**Application no: 23/02153/DISC**

**Location: OS Parcel 9507 South Of 26 And Adjoining, Fewcott Road, Fritwell**

## **Transport Development Control**

<p>Drawing No. A 5 0 2 1</p>	Scale	Initial	Date	1:250 (at A1)	TP	6.22		DAB	6.22		DH	6.22
Scale	Initial	Date												
1:250 (at A1)	TP	6.22												
	DAB	6.22												
	DH	6.22

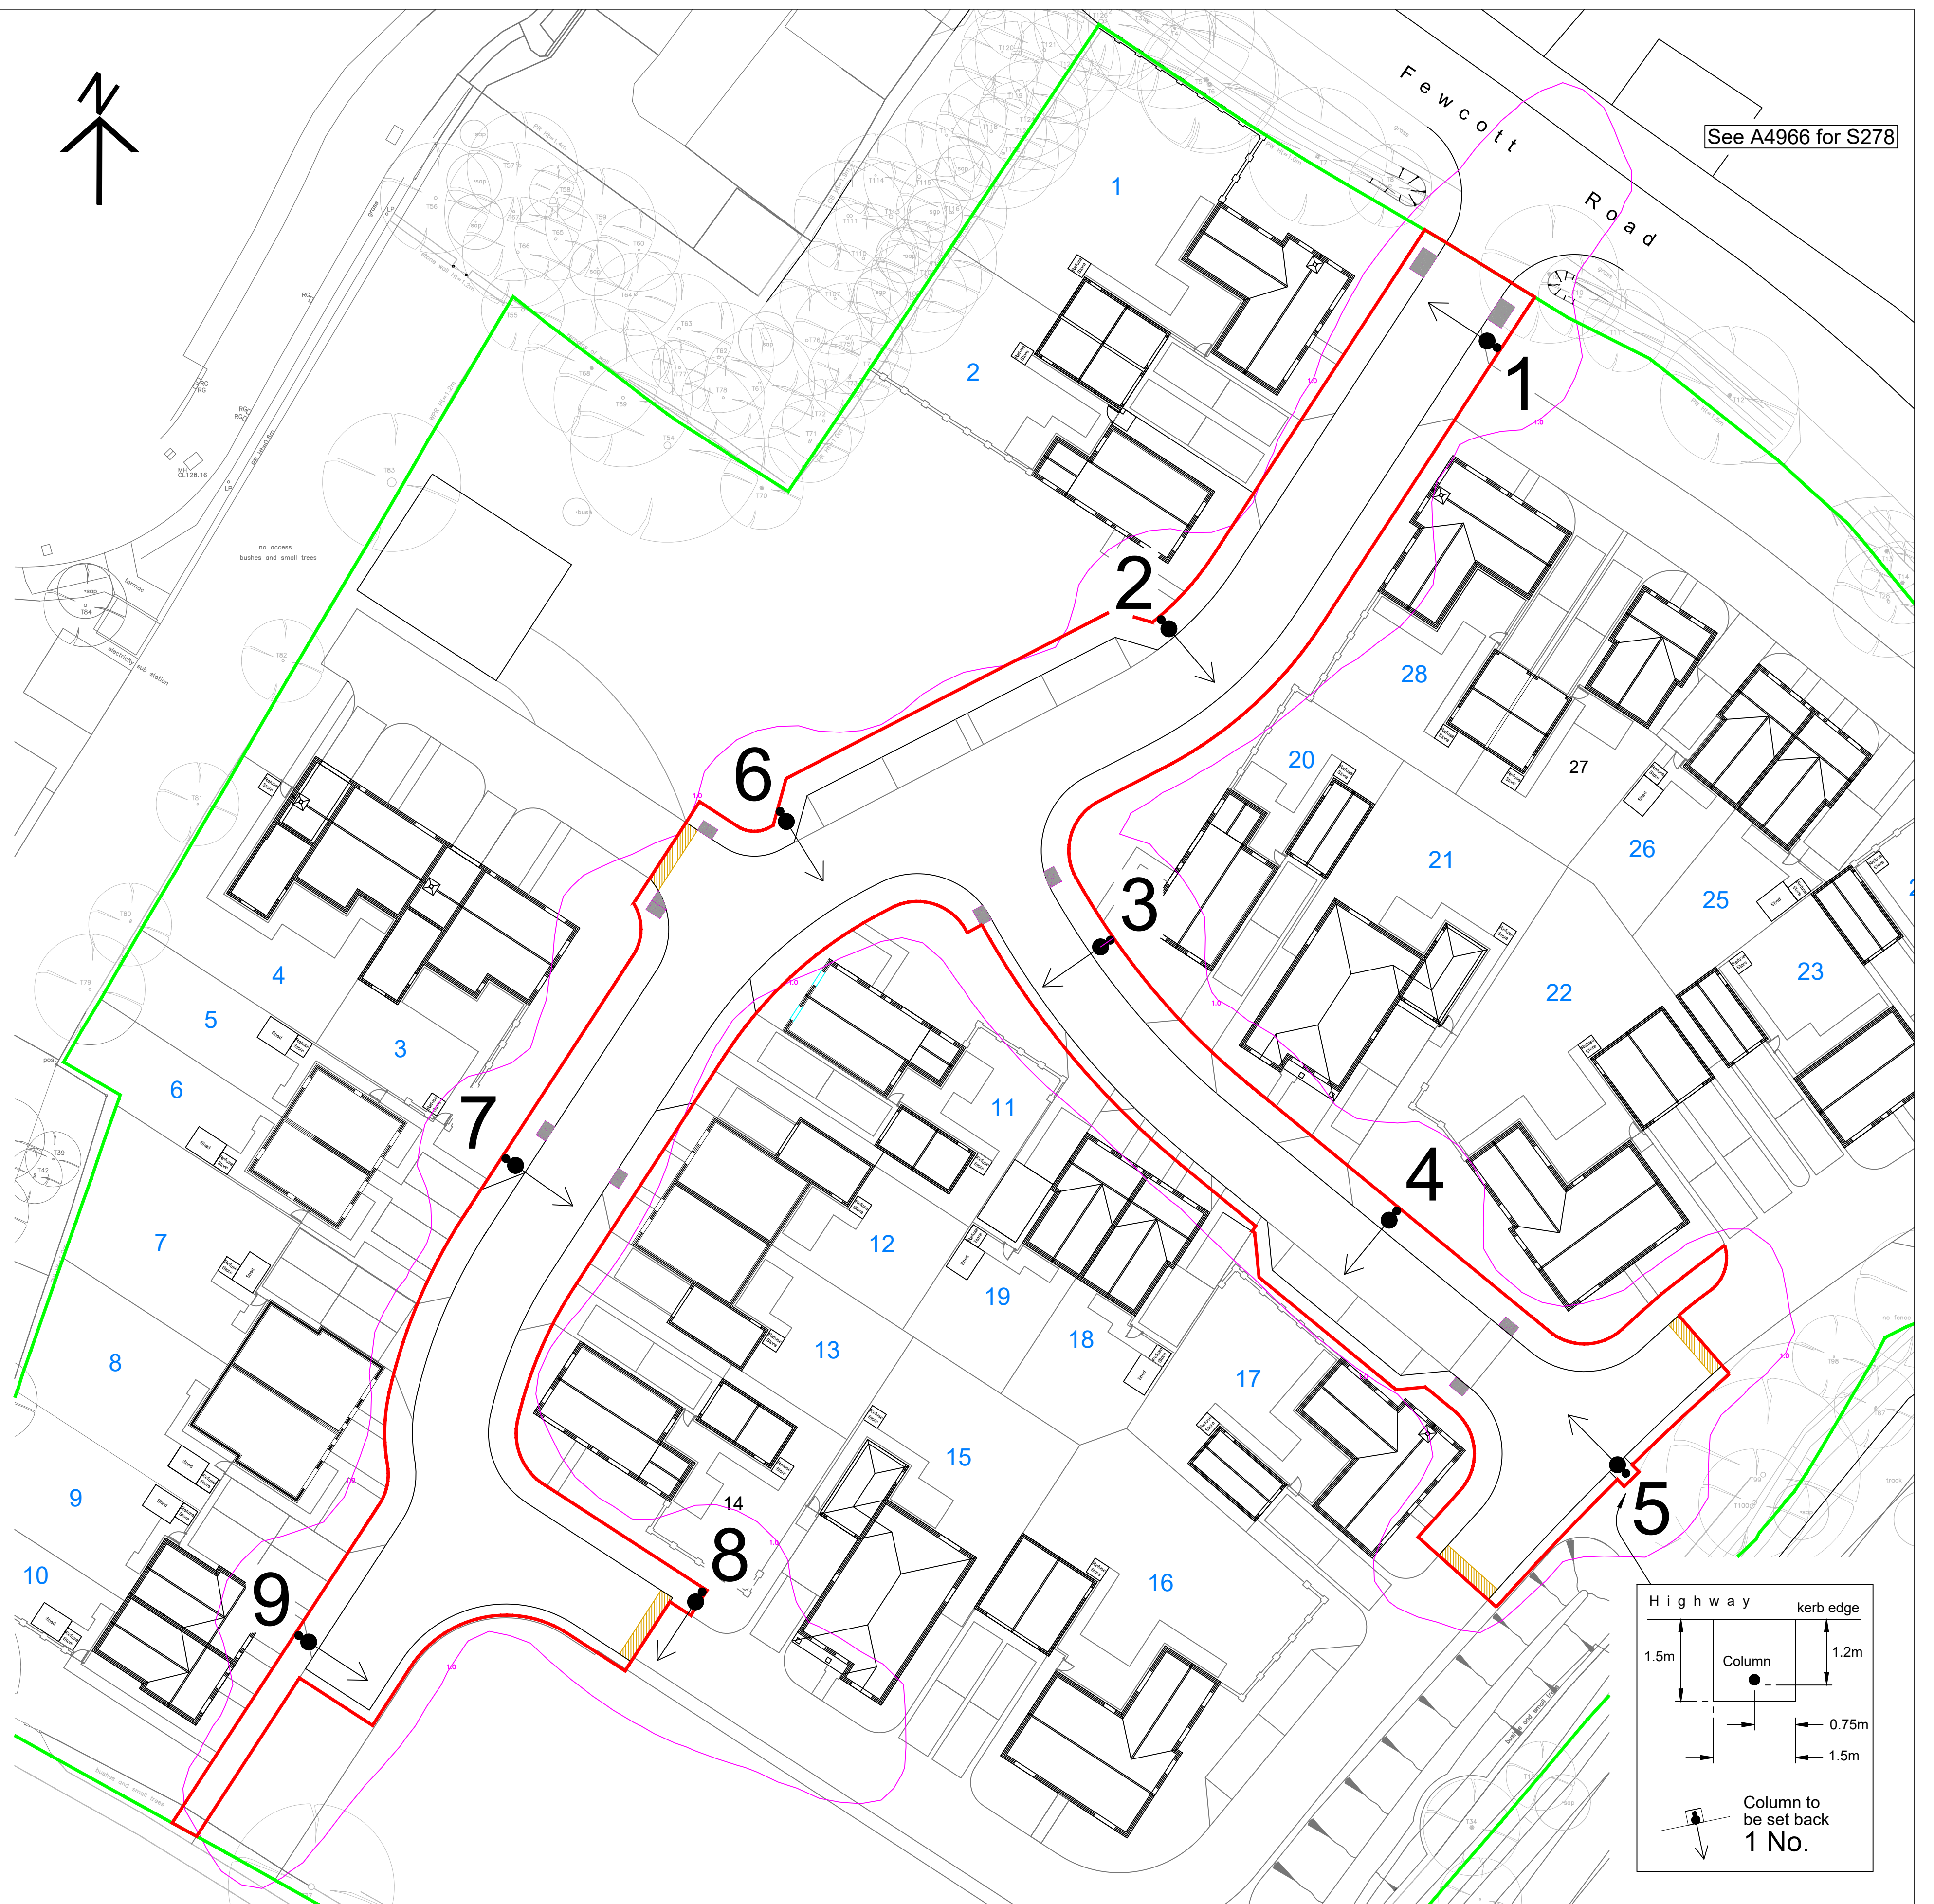
OCC Highways have no comments to make on this condition. The layout is subject to amendments at technical stage when it is reviewed by the OCC Street Lighting Team.
